RFI

RFI #: 117
 Date: 5/15/2012
 Job: EB-02 Keller Springs Lofts
 Phone: 877-777-5115

Subject: Structural Repair Needed at Step From Pour 3 to Pour 5

Subject: Slab Overpour at Pour #1

**S2.16**

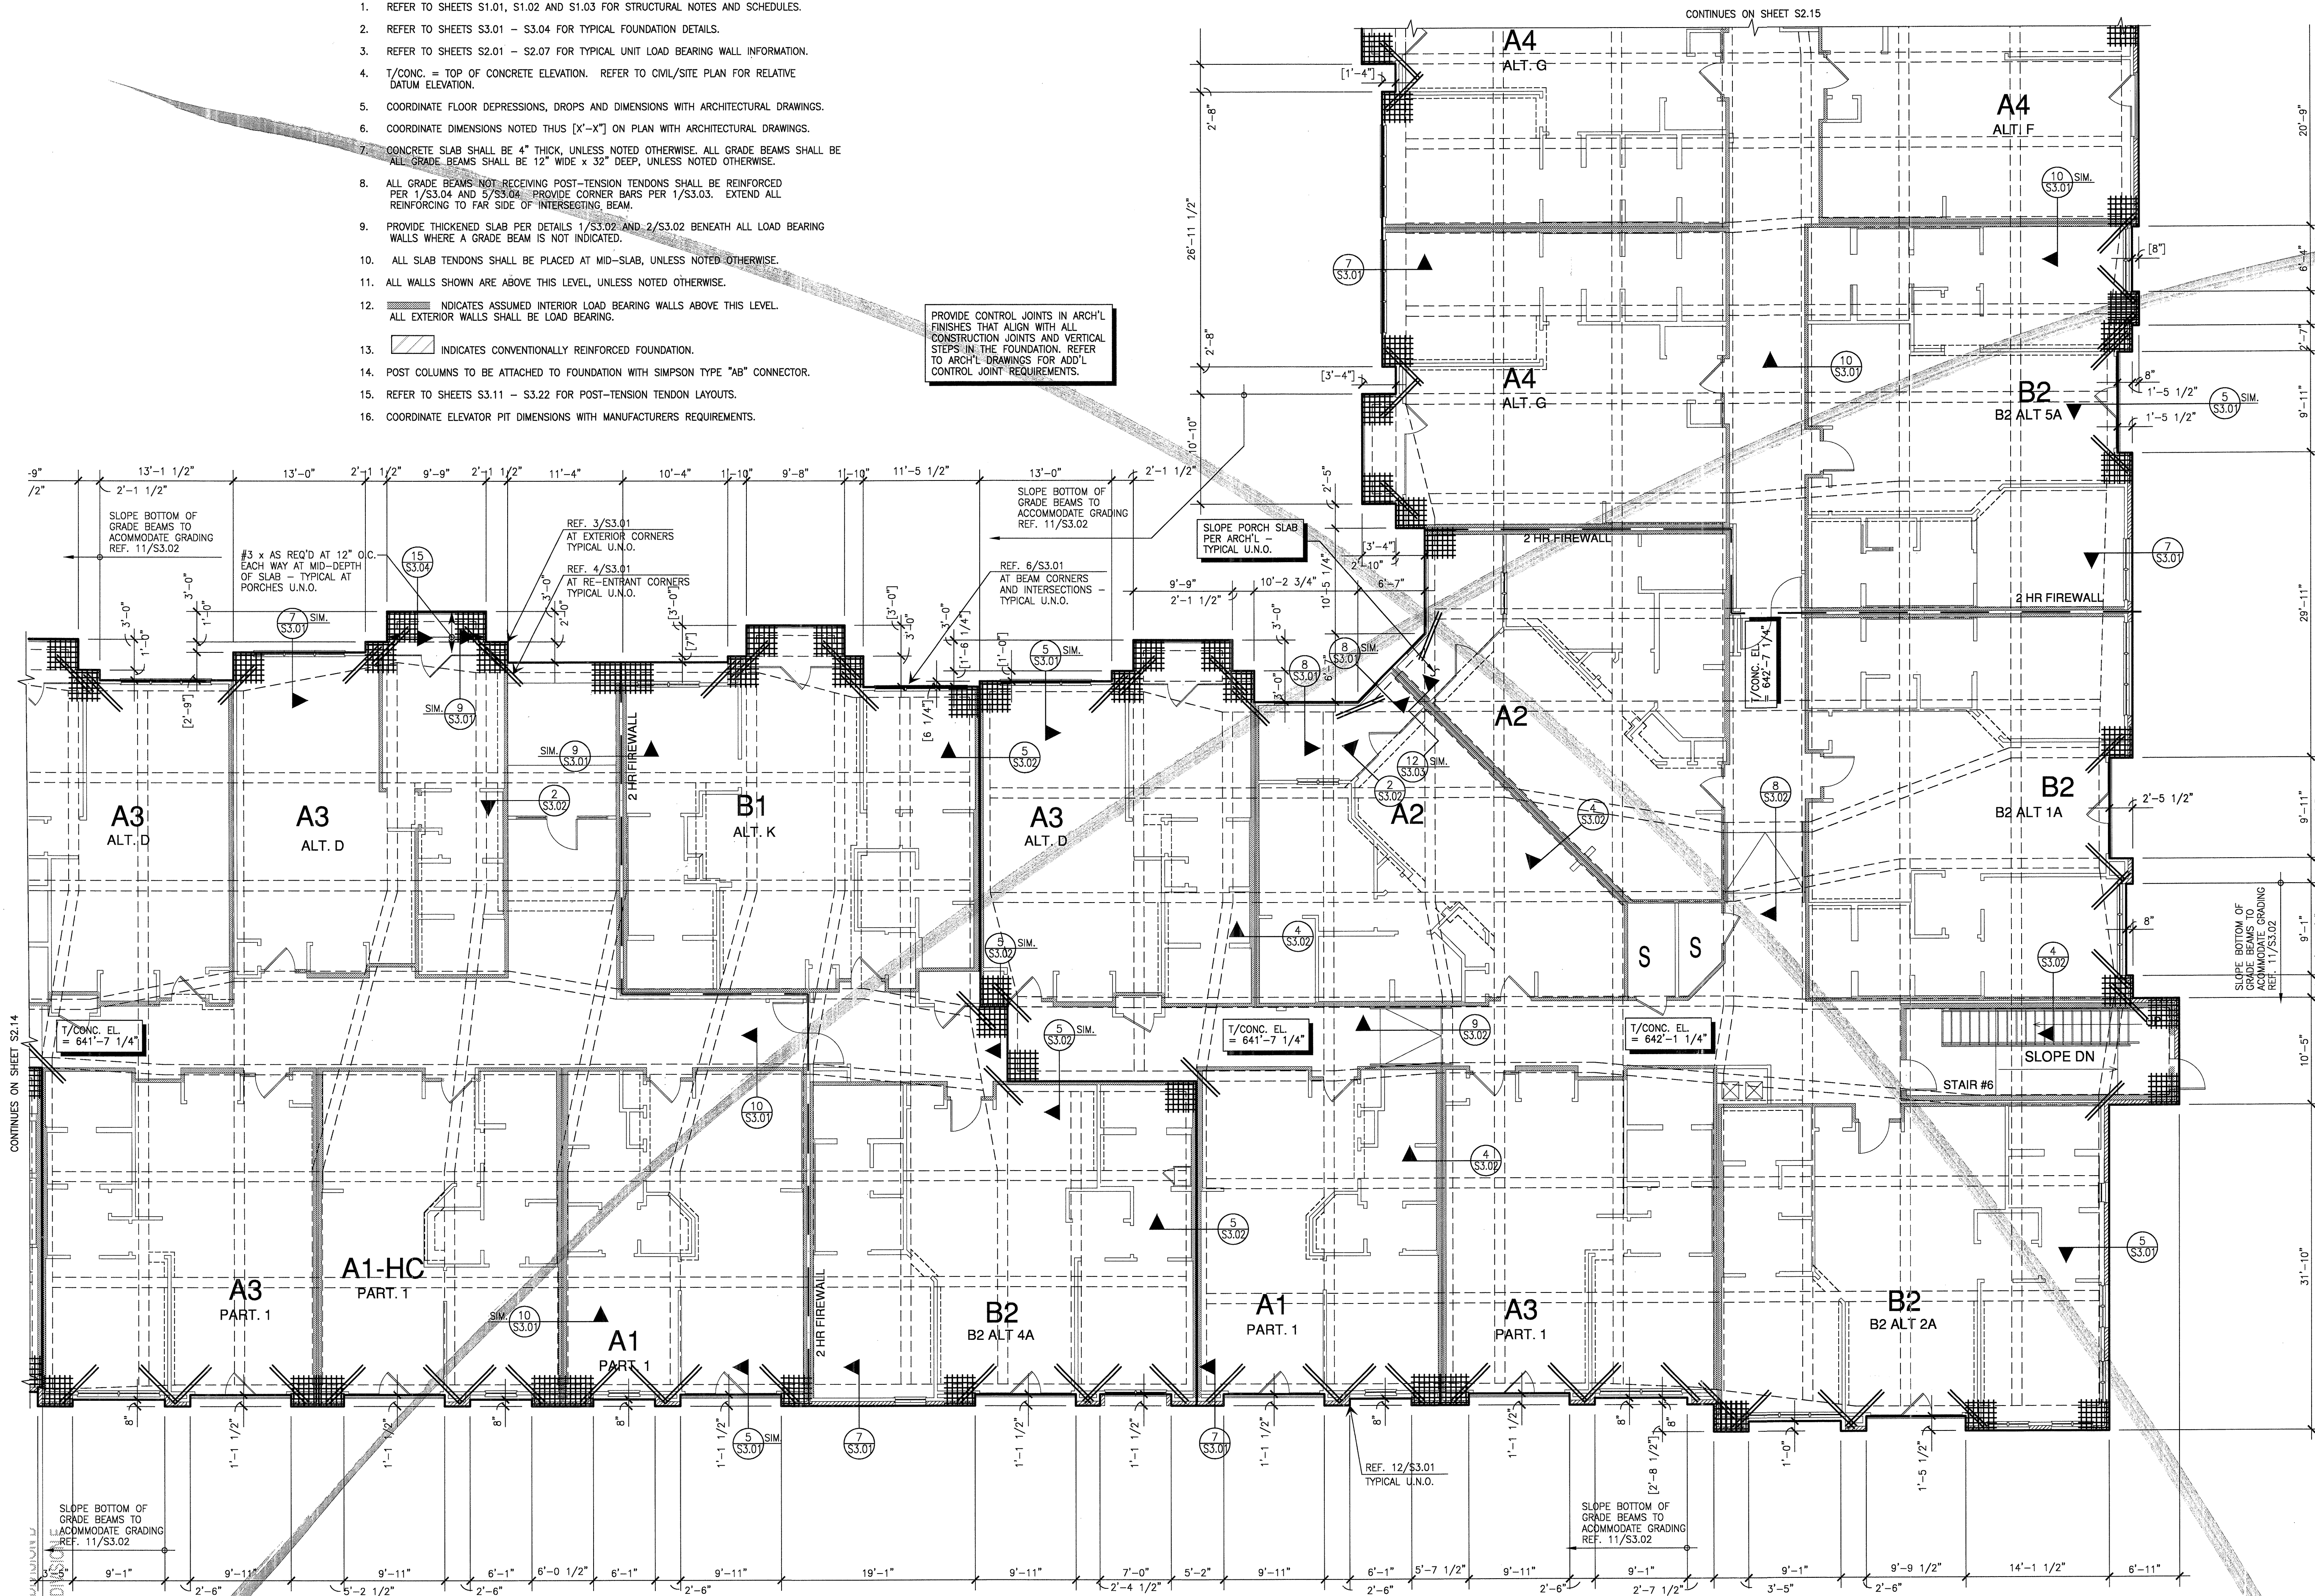
Request: Date Required: 5/22/2012
 At the 12" step down between pour #3 and pour #5 the forms for pour #3 got out of square to the east of the proper line. At our site meeting on 5/11 with PPO (Brandie Parkey) we looked at possibly using a treated 2x12 shot or anchored into the face of the #3 slab. This would be used for additional bearing for the 3 1/2" stud party wall for #3. Attached is the location with the dimension showing the length of the treated 2x12. Please advise and respond.

Response:
 Attach vertical, pressure-treated 2x12's (cut so that the end of the 2x12's flushes out with the top of the concrete at the high side of the step) at 11 1/4" on center. Attach each piece of 2x12 with two 5/8"x6 1/2" Simpson Titen HD anchors (see sheet S1.1 for requirements) spaced at 6" on center vertically.

Request: Date Required: 6/5/2012
 The slab at the northeast corner of Pour #1 was overpoured to cover the entire gradebeam instead of half of it. Please provide method to repair.

Response:
 Please see attached sketch for PPO's suggested solution.
 Architect to verify that the presence of this cold joint inside the unit is acceptable.

BGO is in concurrence with PPO's structural detail. Please do not oversize the holes for the dowels. Provide Greenstreak Swellstop Waterstop (<http://www.greenstreak.com/Div3/Waterstops/swellstop.asp>) or approval equal in the joint,
 WK 06/04/2012
